## Redevelopment of Greenwich Hospital (Concept Proposal) SSD 17\_8699

This submission comes from the eight appointed community members who serve on Lane Cove Council's Bushland Management Advisory Committee. It is not a formal submission from that Committee, but, as a result of our common interests and concerns we will focus predominantly on issues related to biodiversity or bushland on, adjacent to, or close to the proposed development.

MARK-UP OF S04/T3 TO SHOW ERRORS/OMISSIONS

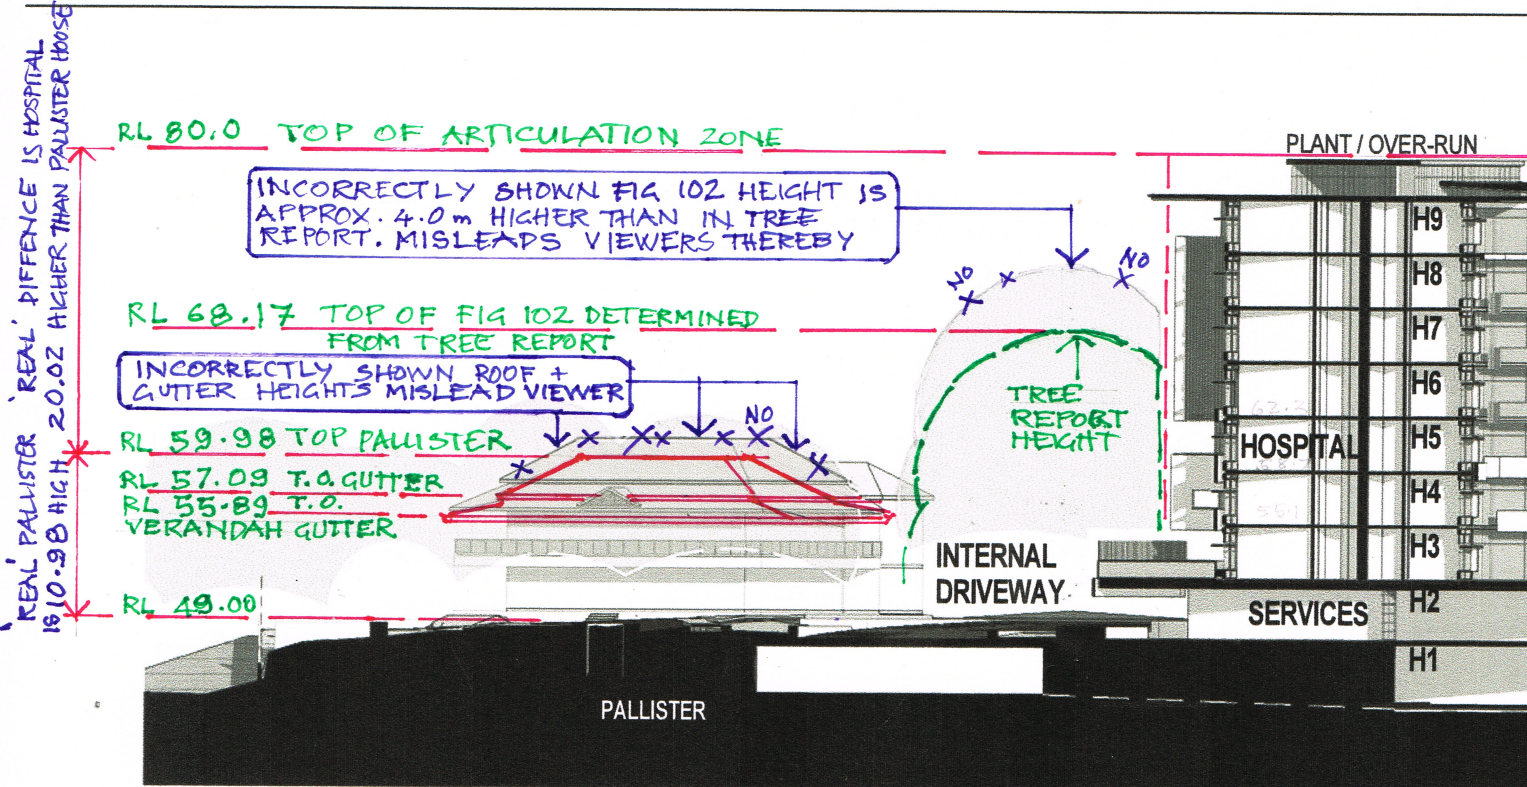
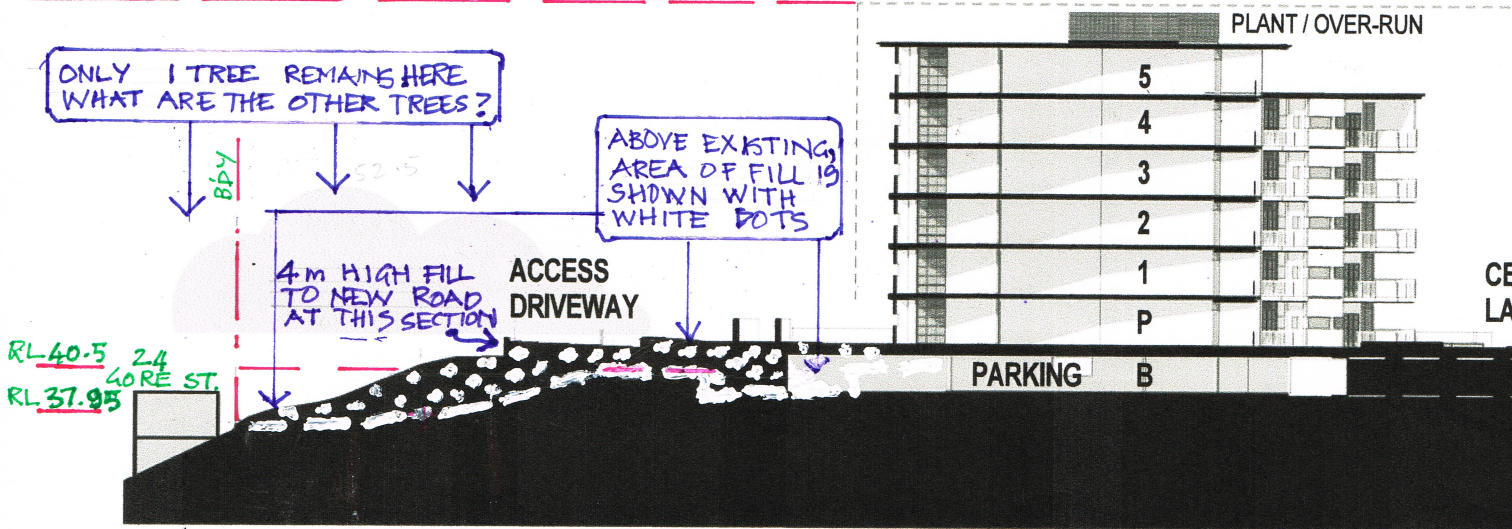
The seniors ILU apartment blocks will have significant landscape impacts viewed from any westerly direction, i.e. from Northwood, from many parts of Gore Creek Reserve, from Bob Campbell oval and its associated parkland, picnic areas and the Northwood foreshore. The architectural plans (Appendix B1) clearly show the height these buildings will reach well above the existing tree canopy level (Street elevation 1 - Drawing S.03, and Cross-section C - Drawing 5.04, Appendix B1). However, there are a number of conflicting statements in the documentation relating to this matter.

However, there are no drawings and only one poor photo montage (from 46 Upper Cliff Drive strategically located from a viewpoint with foreground trees) to demonstrate how these blocks will impact the landscape when viewed from the west. A Lane Cove resident with professional skills in this area has developed drawings using the RLs and other details provided in the project documentation and these are attached in Appendix 1. They illustrate how devastatingly obtrusive these blocks are in the local treed and

Its purpose is to relate RLs of Cross-Section C – Seniors Living Apartments with adjoining bushland, playing oval, creek, homes in Northwood along Cliff Rd, Private Rd and Upper Cliff Rd, so that context is understood as EIS has not provided such information. NB 2 Heritage items have/will have vision of proposal:— E Blackett-designed Northwood House, in Private Road Northwood, and P Frischnecht-designed 40A Upper Cliff Rd, Northwood.
